Please ask for: Mrs D Johnson
Email: daun.johnson@arun.gov.uk
Telephone: 01903 737762
Our Ref: LU/135/21/L
Your Ref:
Date: 29th April 2021

Listed Building Consent for Alterations, Extension or Demolition of a Listed Building

Development: Listed building consent for the subdivision of a single listed building into 2 separate dwellings and essential roof strengthening works.
Location: The Farm 39 East Street Littlehampton BN17 6AU

Location Plan
1:1250

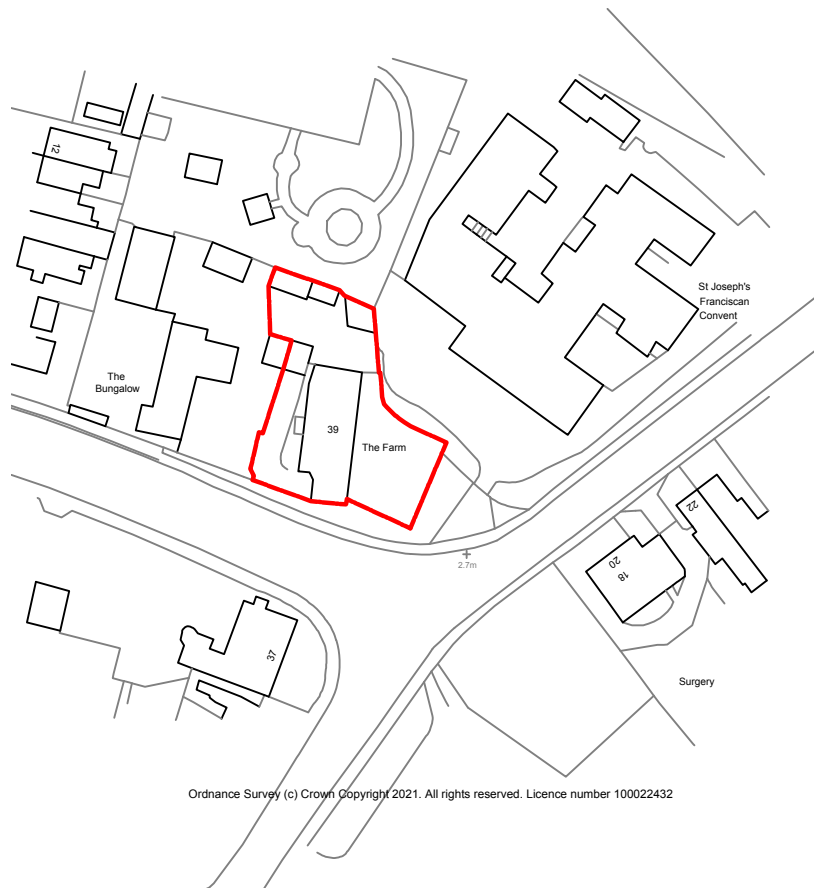
Location Plan

Please provide two named roads.
